WEST SUSSEX COUNTY COUNCIL CONSULTATION

TO:	Arun District Council FAO:David Easton
FROM:	WSCC - Highways Authority
DATE:	8 December 2021
LOCATION:	Land South of Summer Lane and West of Pagham Road Pagham
SUBJECT:	P/167/21/RES Approval of reserved matters (appearance, layout, landscaping and scale) following outline planning Permission P/140/16/OUT for the erection of 375no. dwellings, together with public open space, play space, drainage, parking and associated infrastructure, landscape, ancillary and site preparation works, with access off Pagham Road. This site may affect a Public Right of Way.
DATE OF SITE VISIT:	n/a
RECOMMENDATION:	More Information
S106 CONTRIBUTION TOTAL:	n/a

3. Comments are made in respects of,
 - Site Plan, drawing number 21.003.02
 - Landscape General Arrangement Plans 1-5, drawing numbers L01, L02, L03, L04, L05

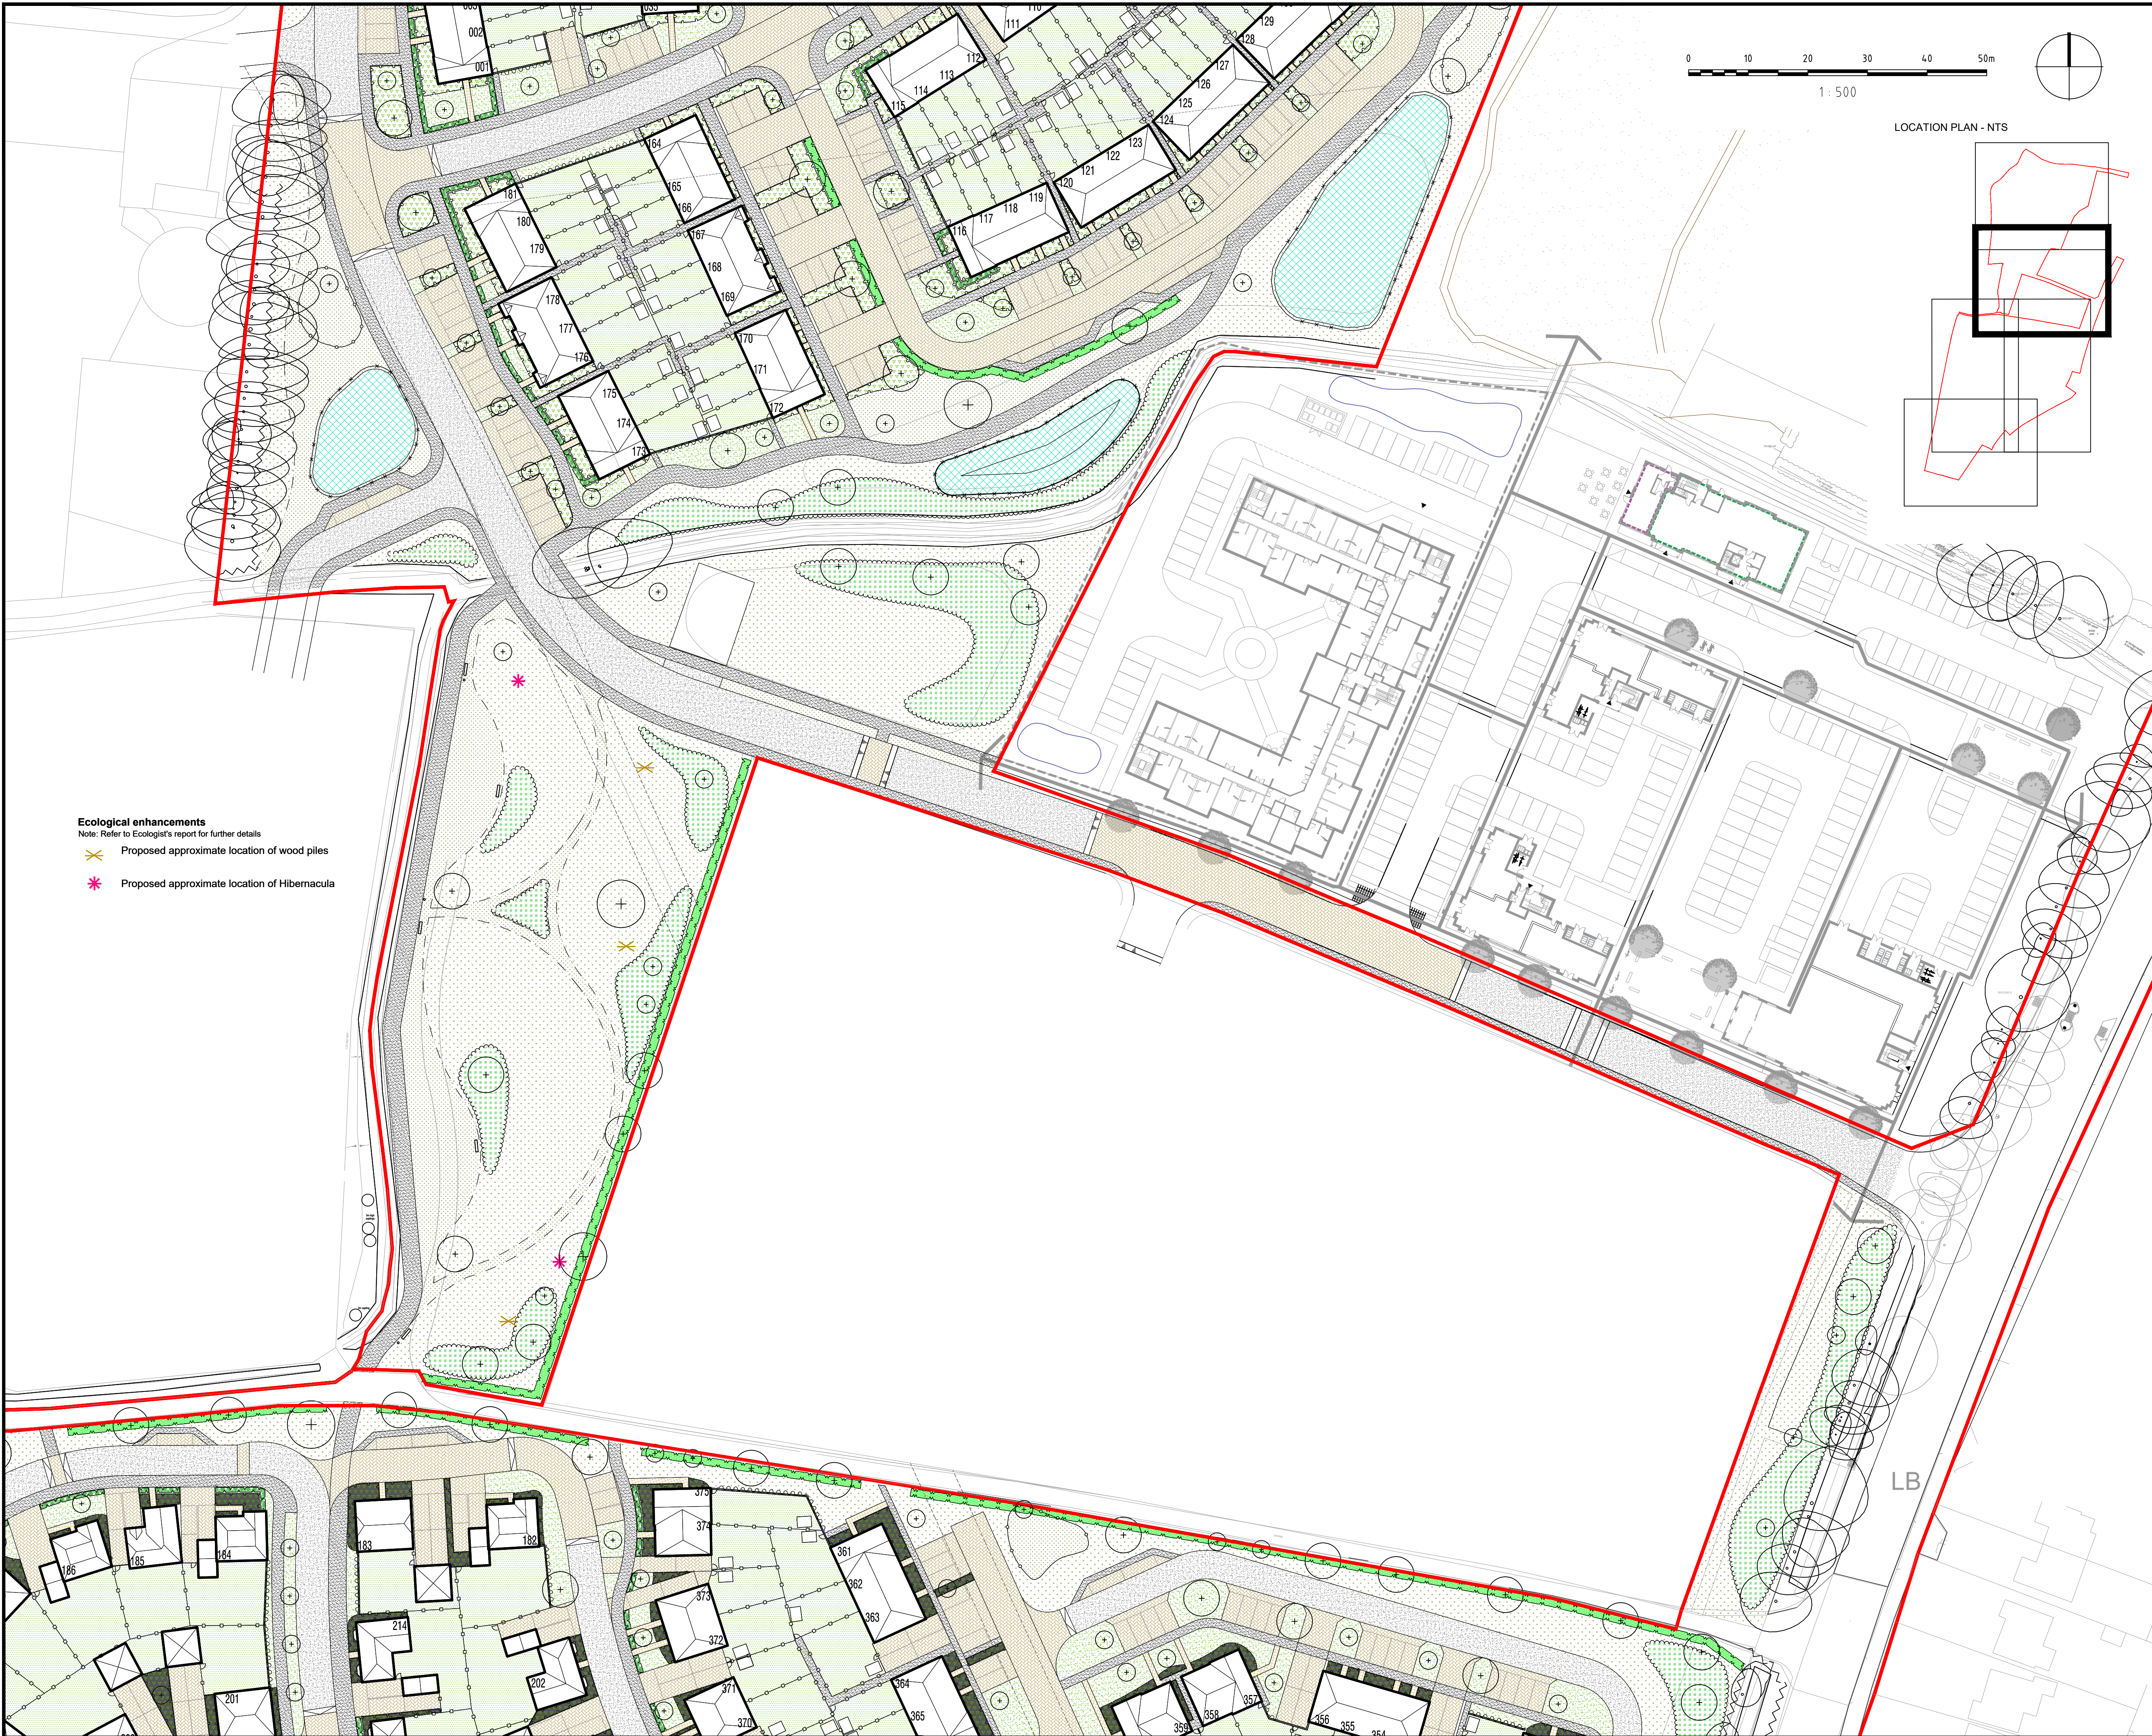
12. Again, for shared surfaces, a contrasting material to that used in traditional carriageway construction must be used. Tarmac should not be used in

shared surfaces. There is a large extent of shared surface within the southern phase of development that is indicated to be in tarmac rather than blockwork.

13. The use of certain materials could be rationalised. For example, it's unclear why driveways and unallocated lay-by parking spaces within traditional carriageway construction are in blockwork whereas the surrounding carriageways and footways are tarmac. In the event that roads within the site are offered for adoption, WSCC will likely seek the use of tarmac for driveways and lay-by spaces where the adjacent carriageway is also tarmac.
